November 23, 2022

**Re: Project no. PR-2022-007701, Application no. SI-2022- 01868
New Branch office for Nusenda Credit Union at 2801 Juan Tabo NE, Abq NM.**

The following are responses describing how we comply or are addressing staff comments of 11-16.to follow IDO and other requirements for site plan approval:

Landscape
Plan

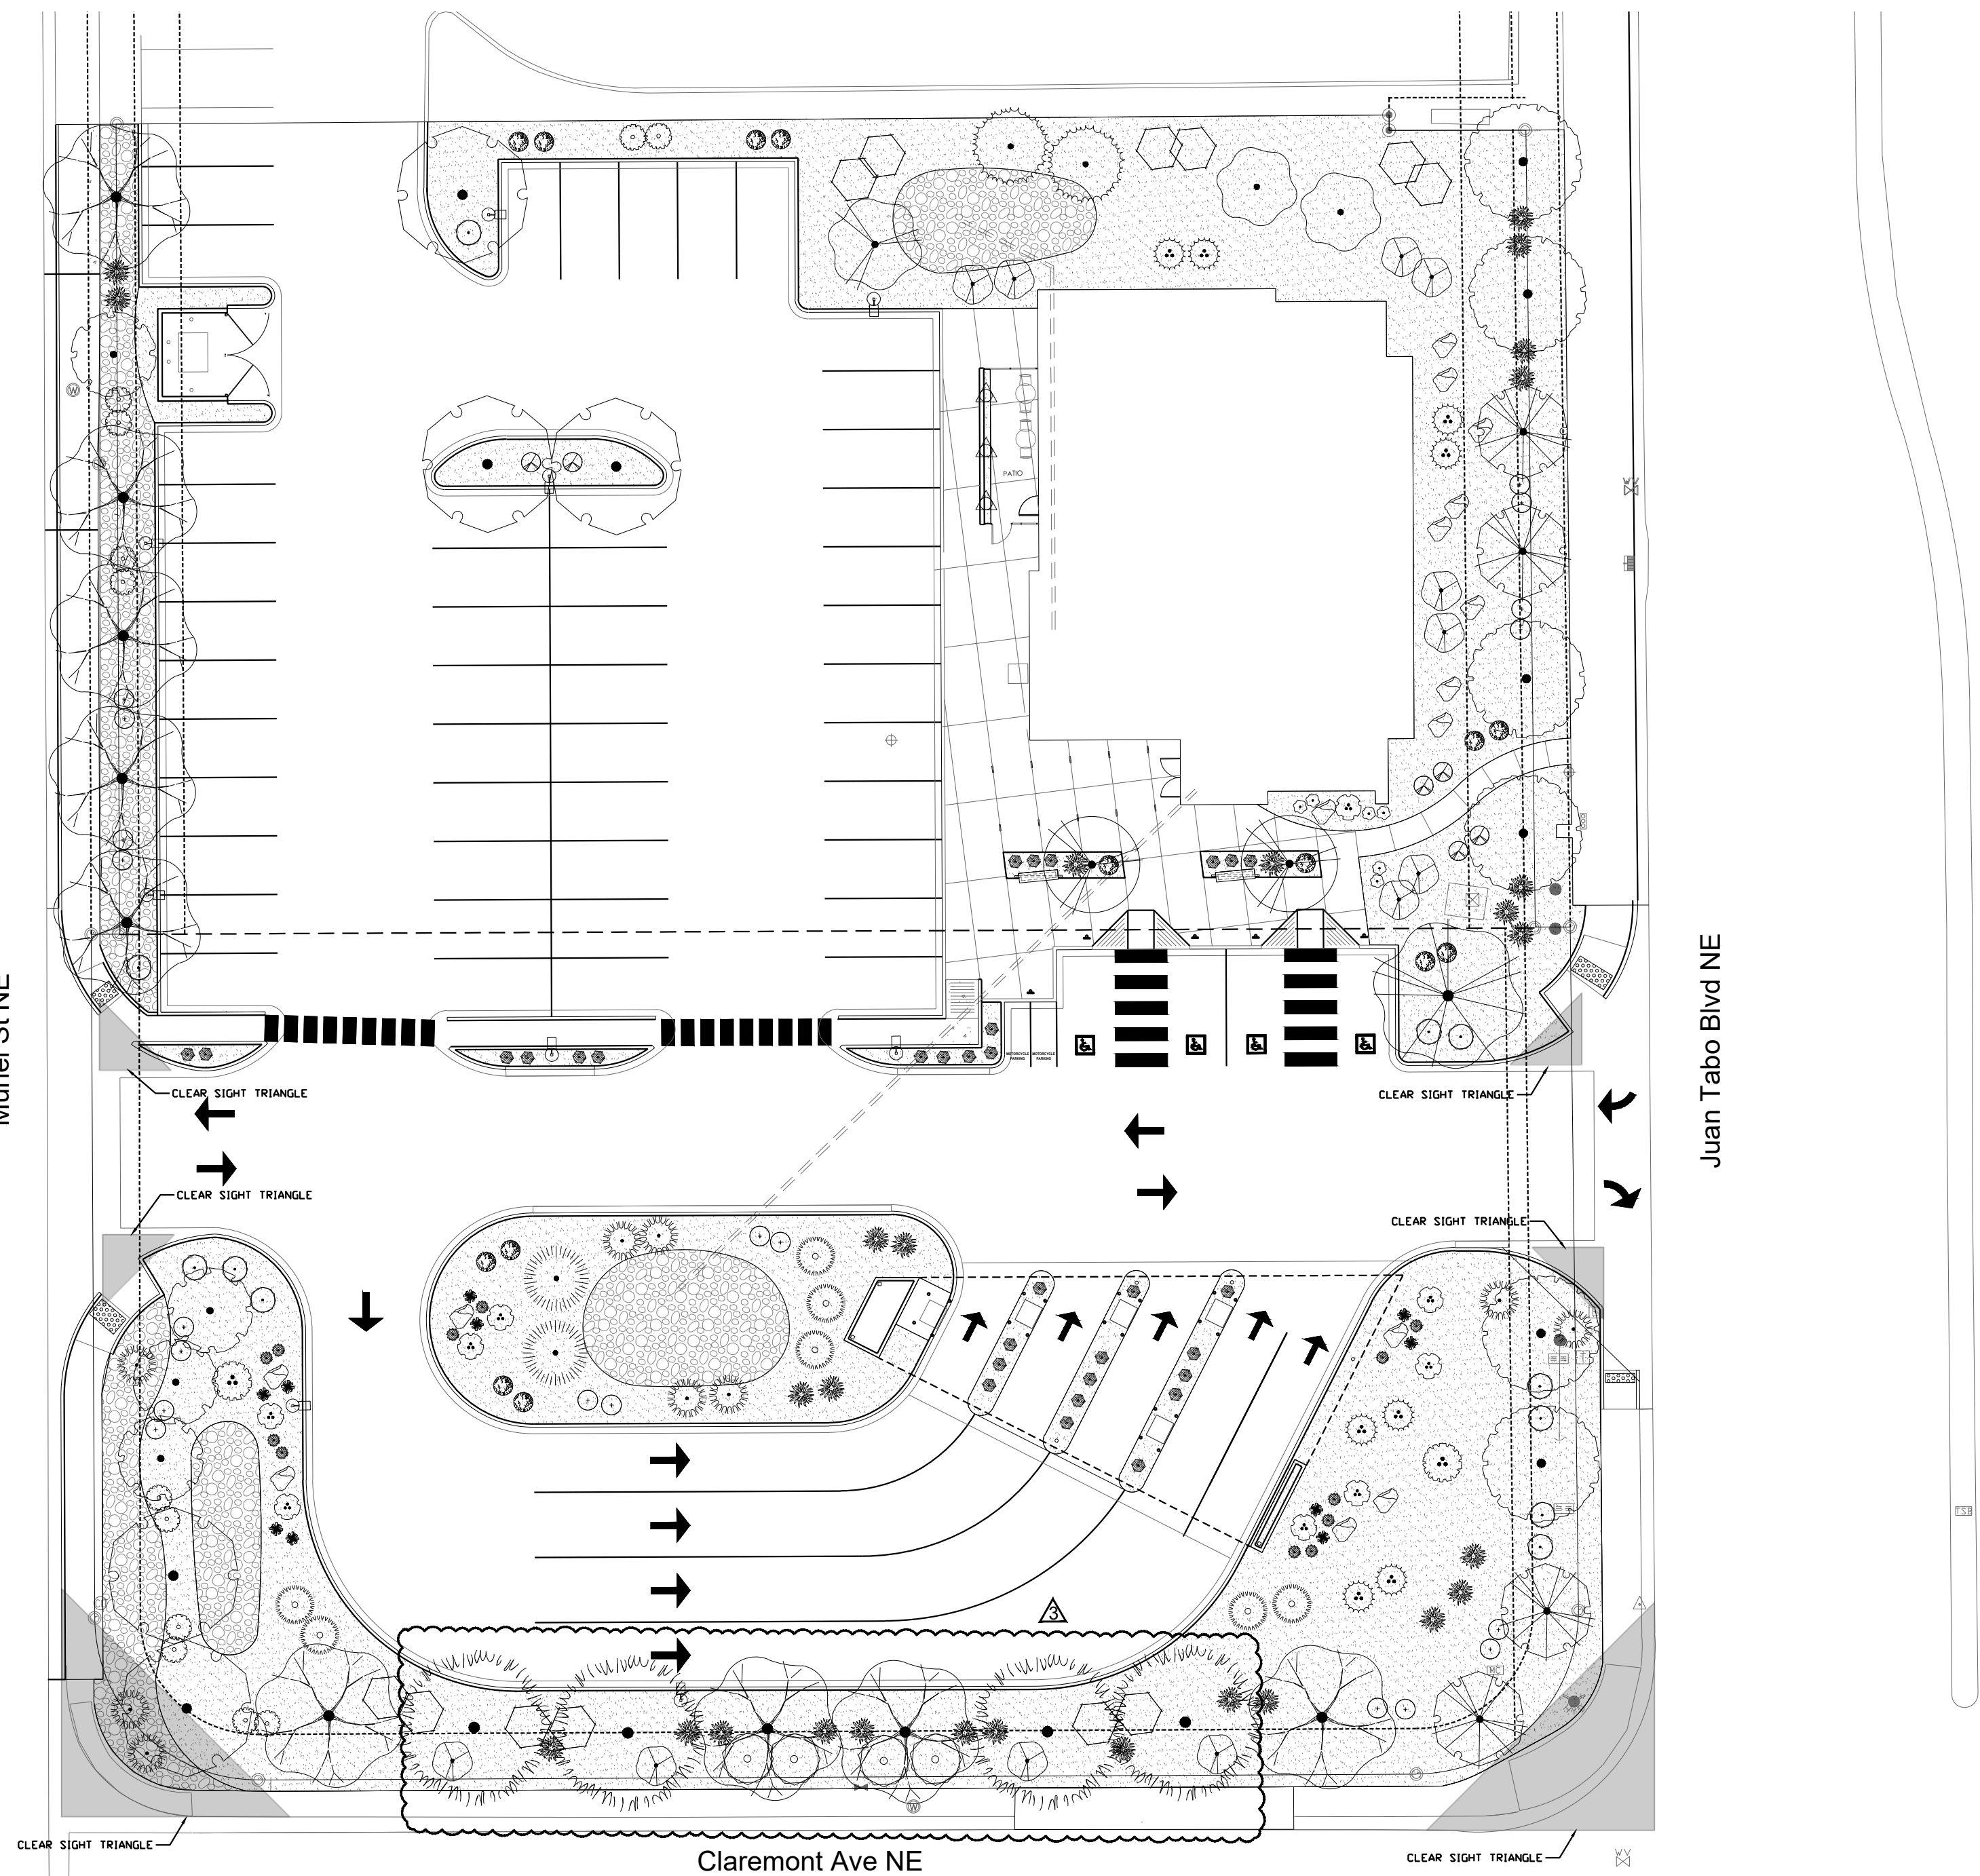
1. Comments in regard to platting action will be addressed in replat process which is underway and being done by others.
2. 5-6. An updated landscape plan is attached here. The trees along the south property line have been changed to evergreen trees so that the buffer requirements as described in IDO 5-6 are met. The landscape calculations as described in IDO section 5-6 are clearly shown on the sheet. The calculations show that the plan is in compliance with these requirements.
3. The mechanical screens on the roof extend to a higher elevation than the mechanical equipment so the screening requirement as described in 5-6(G) will be exceeded. Building elevations illustrating this are attached here.

1. An updated landscape plan is attached here. The trees along the south property line have been changed to evergreen trees in order to comply with the IDO page 607. The buffer will be 75% opaque, minimum upon maturity.
